REQUEST

Current Zoning: R-5 (single family residential)
Proposed Zoning: UR-2(CD) (urban residential, conditional)

Approximately 1.64 acres located along the east side of Catalina Avenue, south of West 28th Street, and north of West 26th Street.

STAFF RECOMMENDATION

RZ2

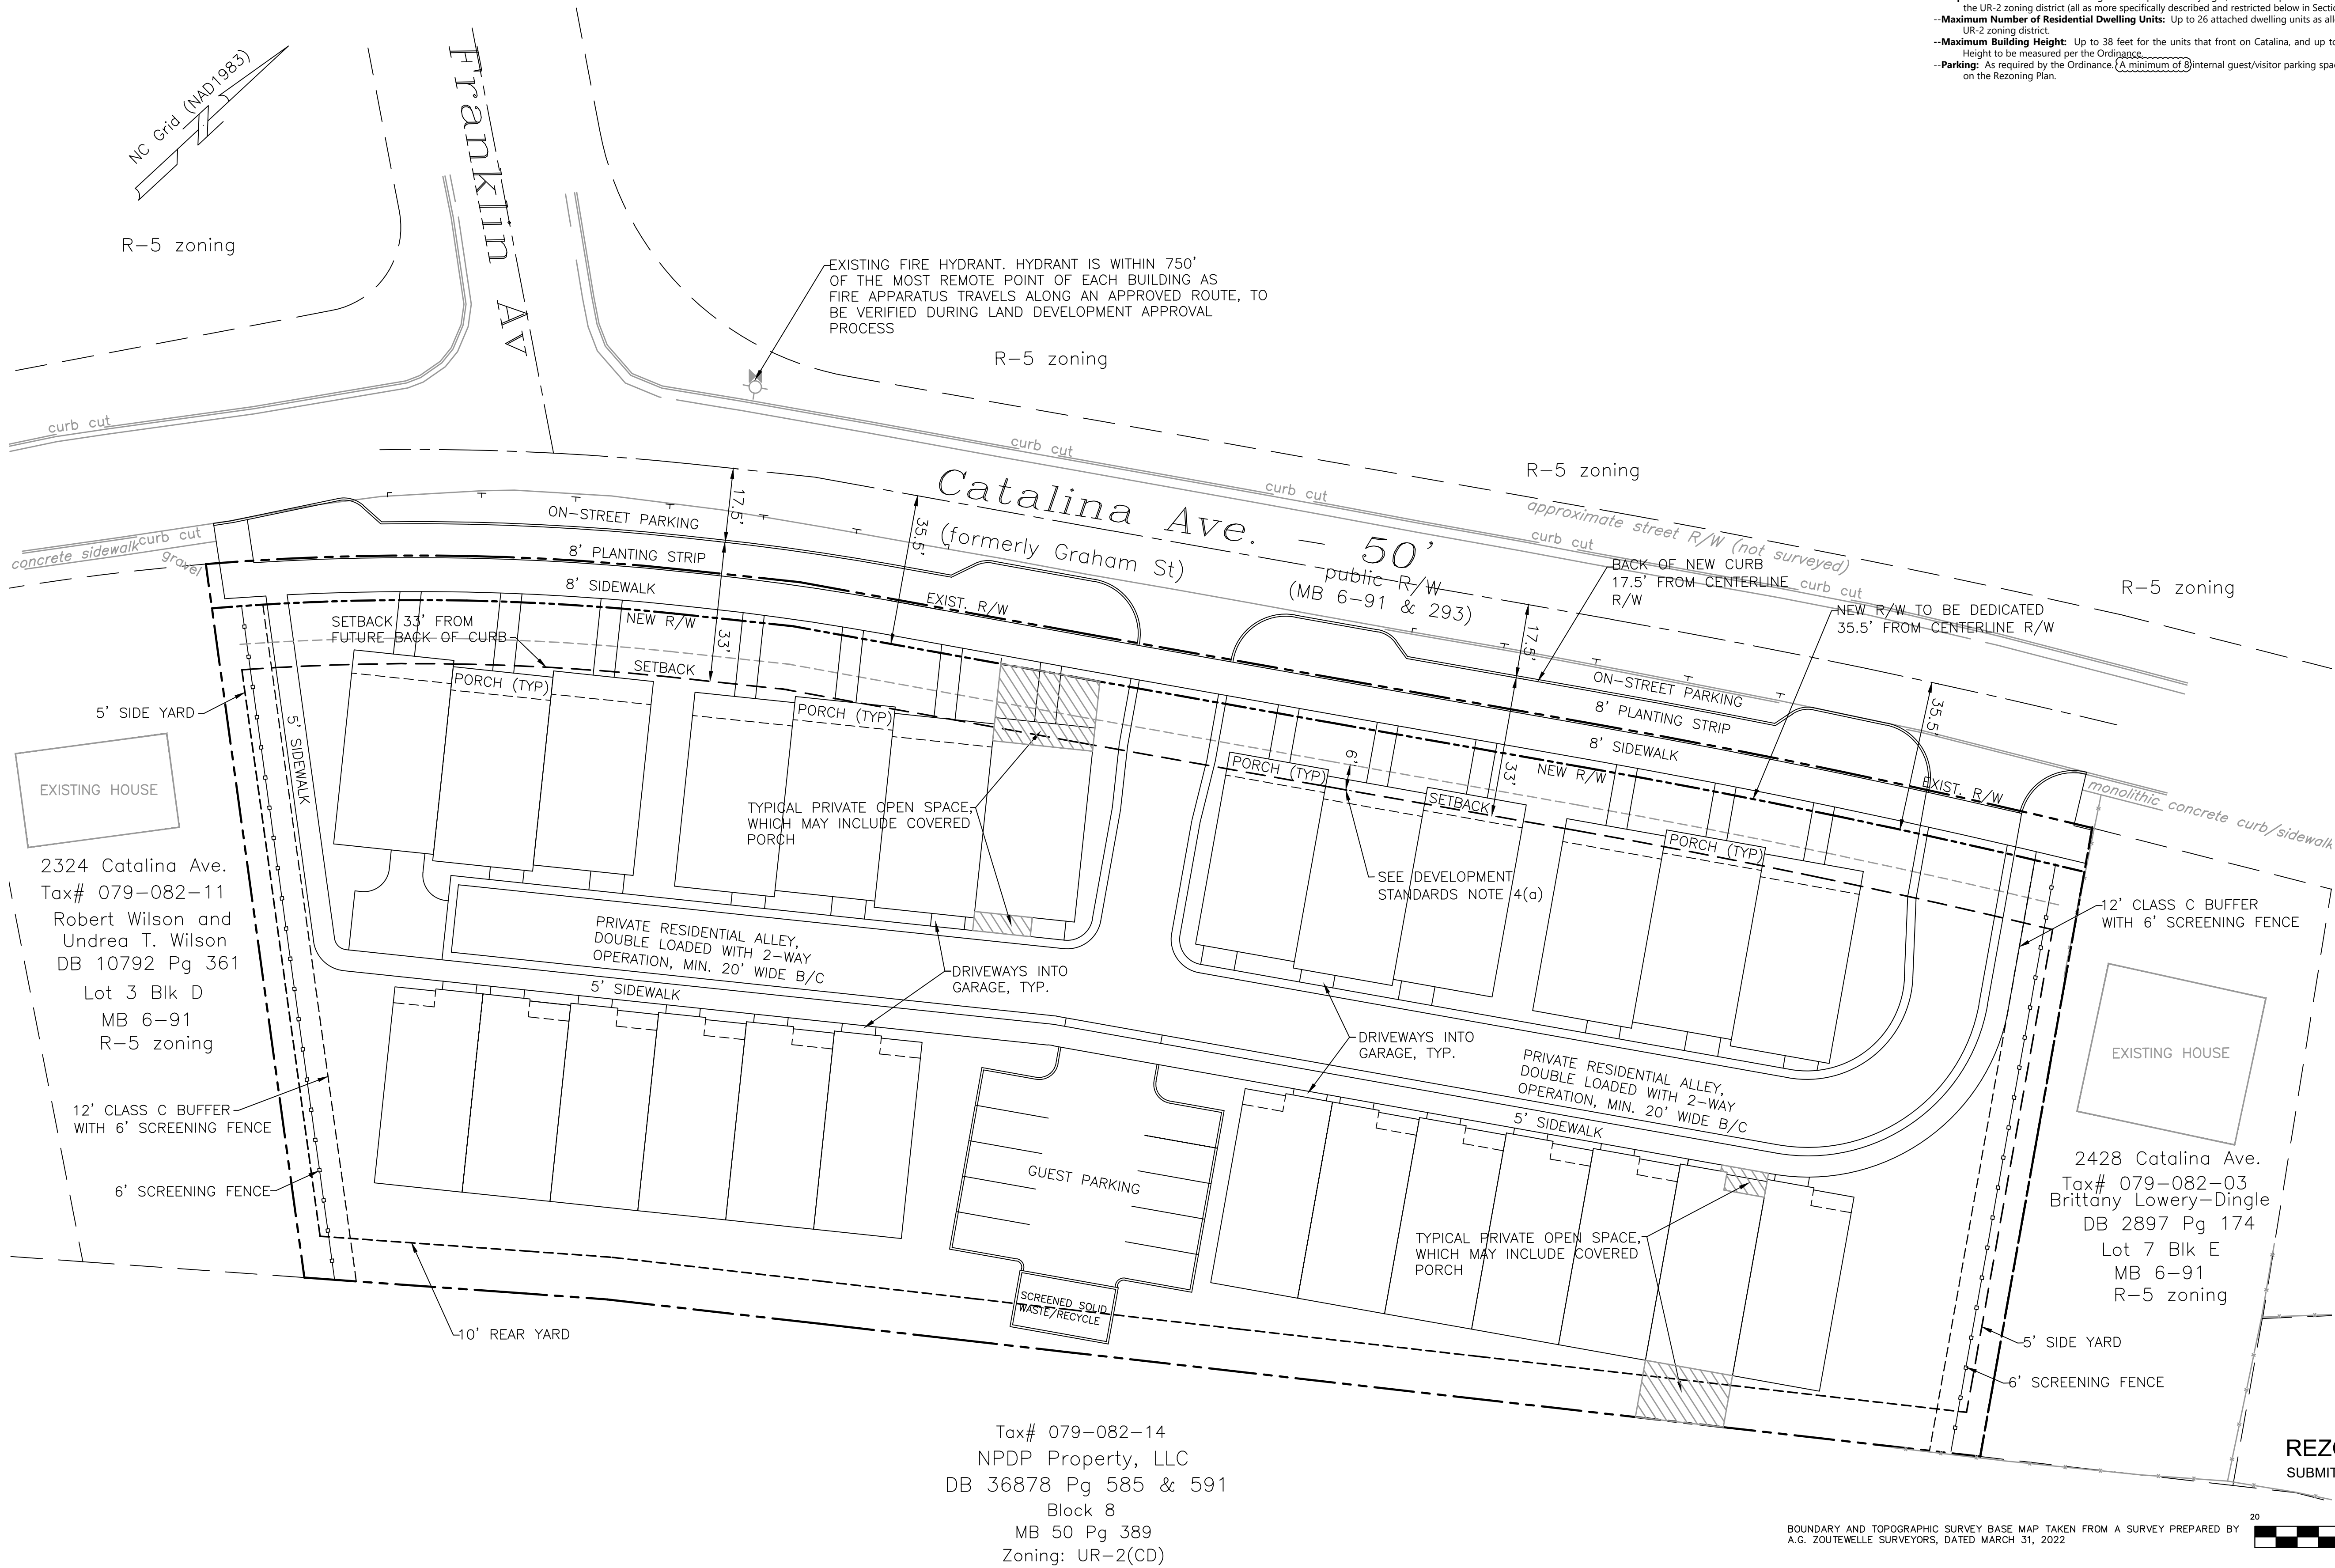
1. Revise the site plan so that no structures are located in the setback.
2. Relocate the proposed screened solid waste and recycling area so that it is not within the rear yard or 5' of the property to the rear.
